THIRU. PAVAN RAJIA, I.A.S.,
Member-Secretary,
Madras Metropolitan
Development Authority,
No.8, Gandhi-Irwin Road,
Egmore, Madras-600 008.

Letter No. A1/5521/91

Sub: MMDA - Planning Permission - Construction
of residential building in Plot No.102A part
at S.No. 4433 of Nylapore village - Approved -
Regarding.

SITE PLAN NOT TO SCALE KEY PLAN

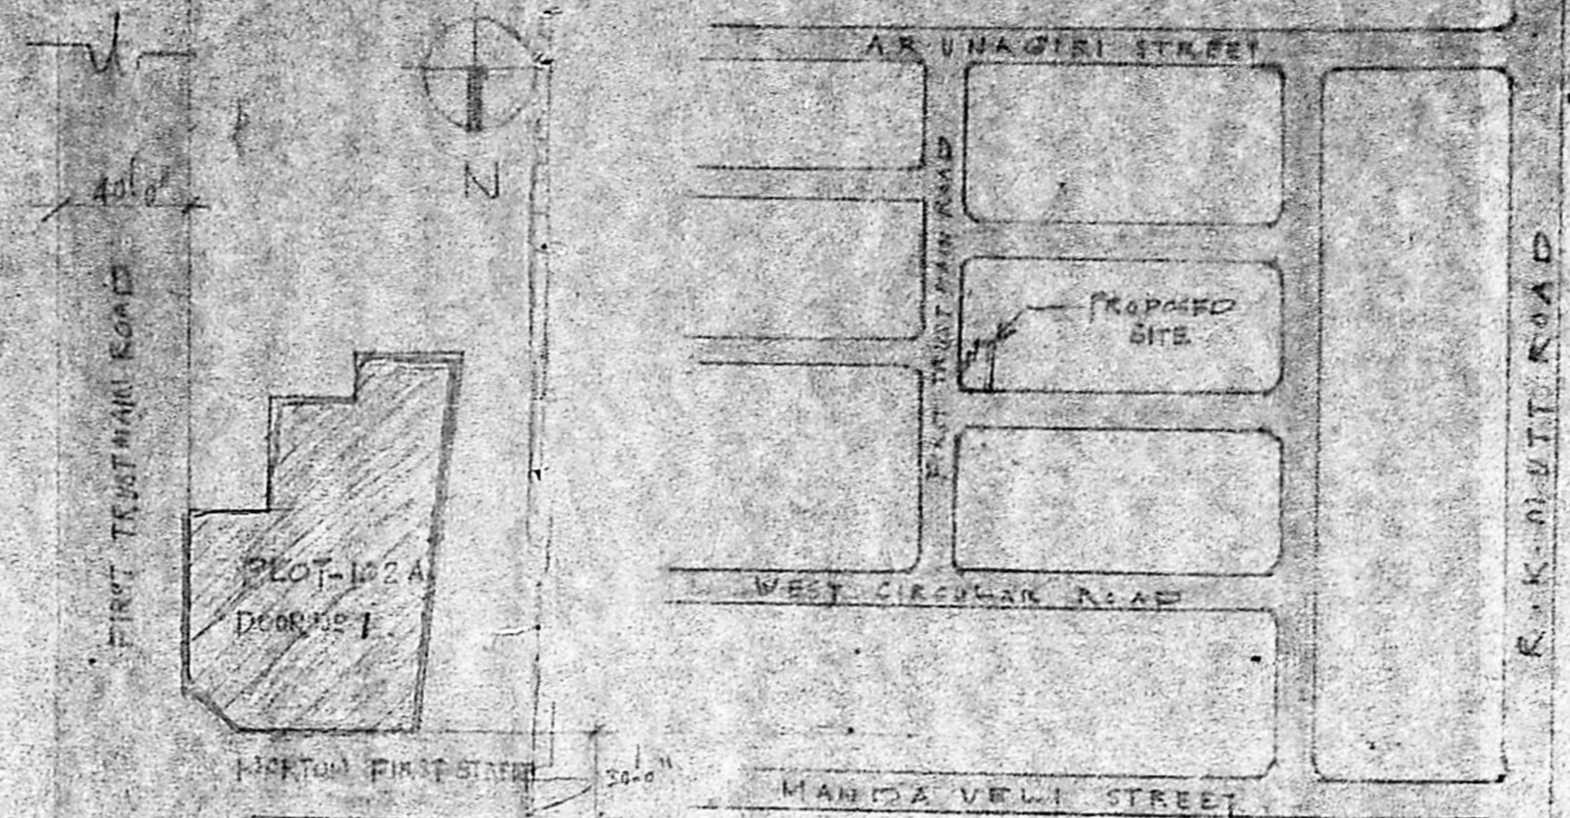
towards Regularisation charge by two separate Demand Drafts of
a Nationalised Bank in Madras City drawn in favour of the
Member-Secretary, MMDA, Madras-8 or in cash/and pay at MMDA
office Cash Counter between 10.00 A.M. and 4.00 P.M. within
10 days and after remit the said amount, you are requested to
remit the duplicate receipt to Area Plans Unit. You are also
requested to submit the Affidavit for ULC in Rs.5/- stamp paper
duly attested by Notary Public. Planning Permission application
will be returned unapproved if the amount are not paid within
the stipulated time. You are requested to furnish revised plans (5 Nos.)
with incorporating 3M x 3M splay.
